Householder Proforma

Application Ref: 2021/1489

Address: 7 Wellfield Grove, Penistone, S36 8GP

Drawing Number: 2128/TP/004

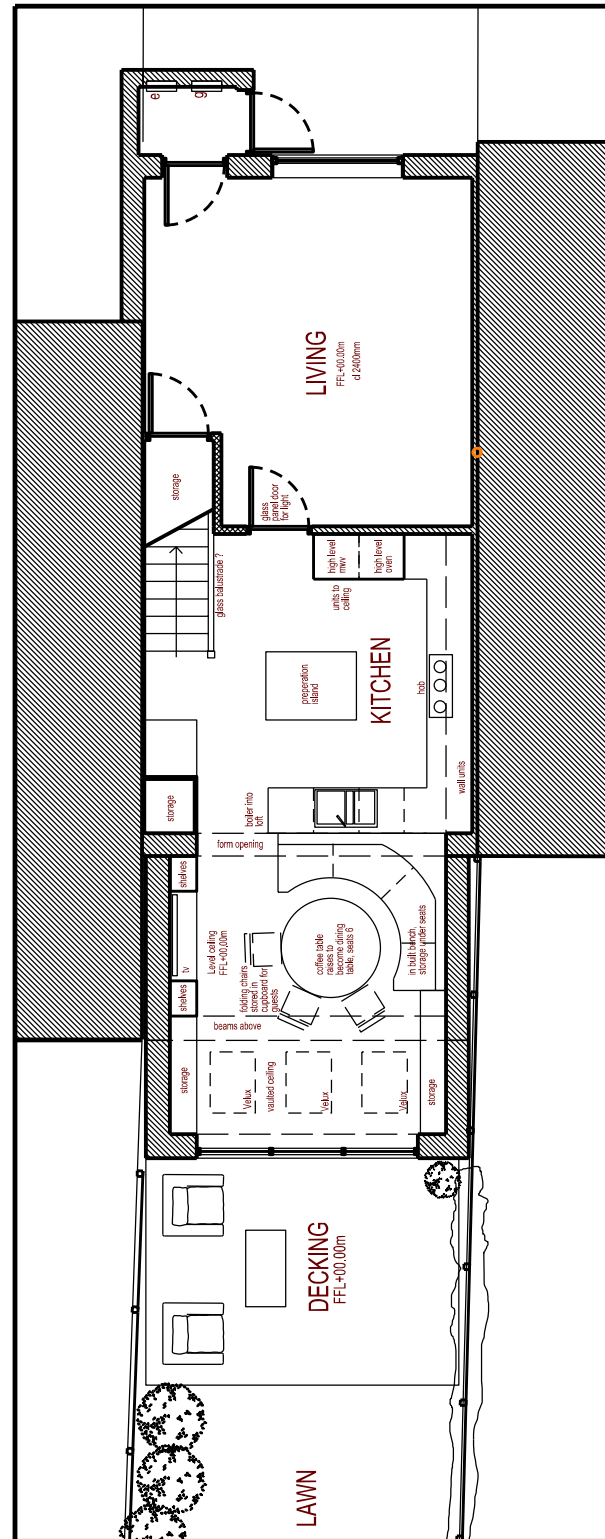
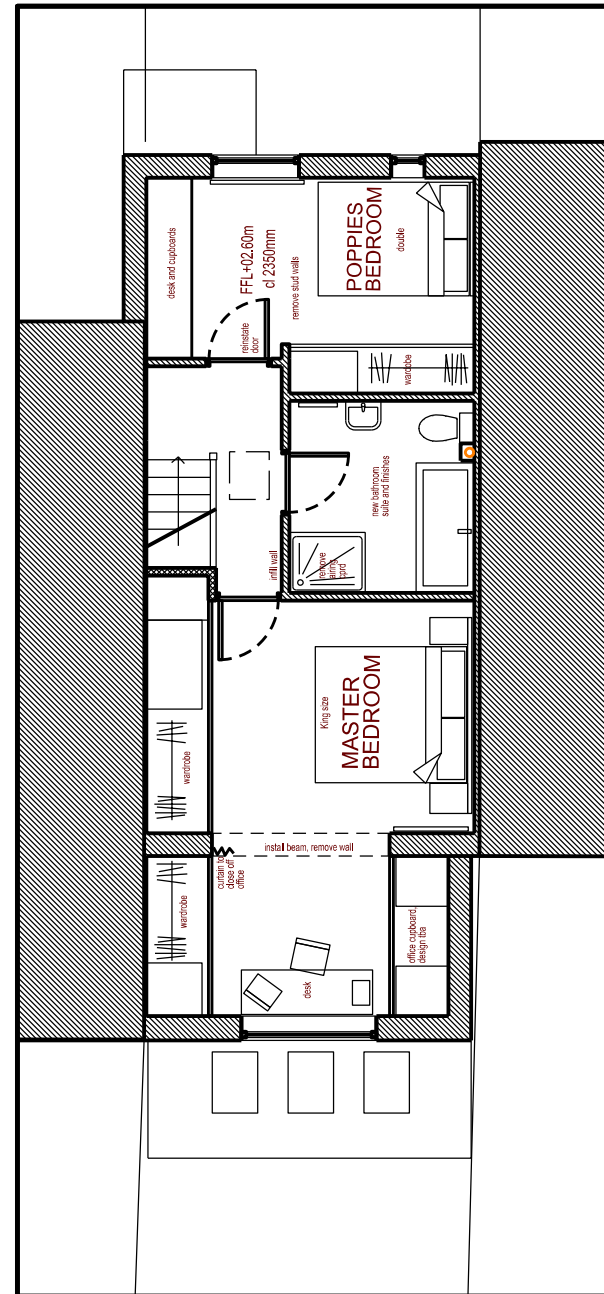
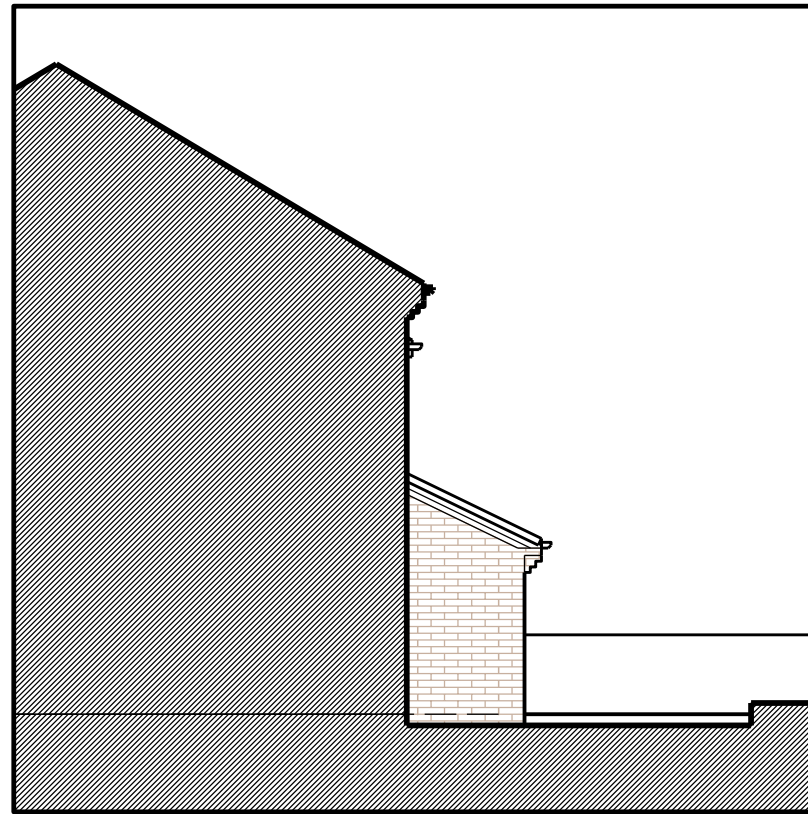
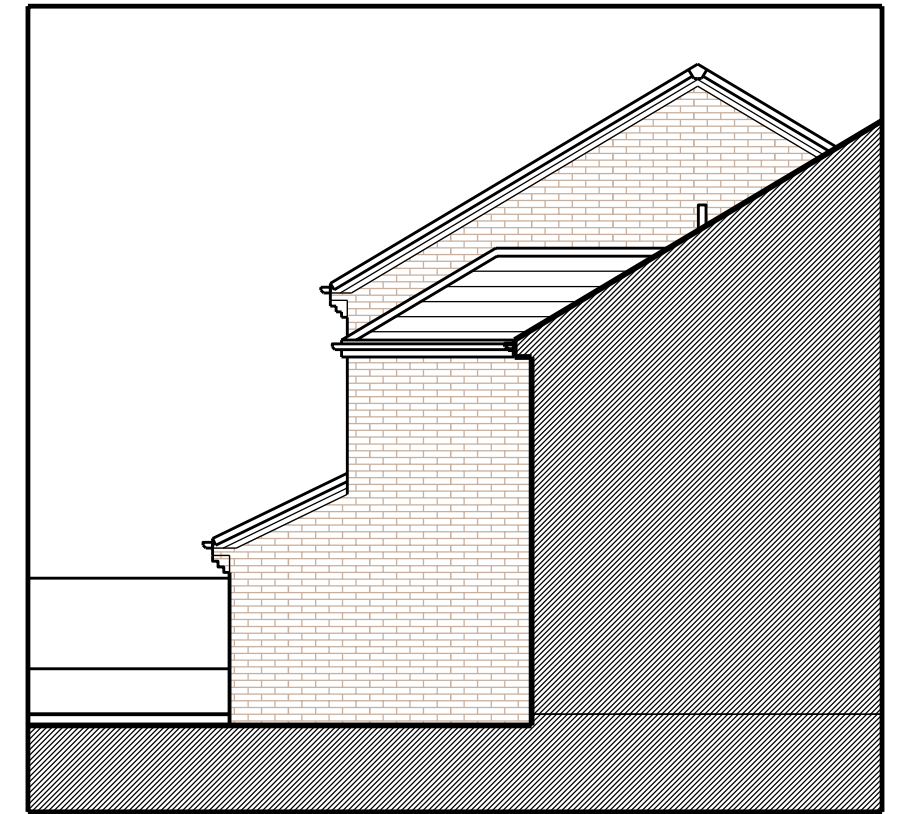
The proposal is for a 2 storey and single storey extension to the rear of the property. The size and proportions are modest and in compliance with Planning Policy. The rear windows are over 21m from the residential properties behind. The rear projection is in line with Local Plan Policy for terraced properties. The proposed extension will be built in matching materials and is not expected to cause any detriment to both residential and visual amenity.

Yes
Single Storey	
1. terraced property and less than 3.5m (projection to rear)?	Yes
2. semi-detached and less than 4m?	
3. if more than 3m are the eaves more than 2.5m in height?	No, they are 2.38m
Two Storey	
4. terraced property and less than 2.5m (projection to the rear)?	Yes
5. semi-detached and less than 3.5m?	
All	
6. materials to match	Yes
7. roof design compliments / ties in well	Yes, ties in with existing

8. habitable room windows on the side elevation?	No
9. distance to rear boundary (shared with another residential property) 10m or more?	9.85m, which is just short of 10m. To mitigate the properties to the rear are not back to back, the property has a good fenced boundary, therefore unacceptable overlooking is not expected and existing residential amenity will not be compromised.
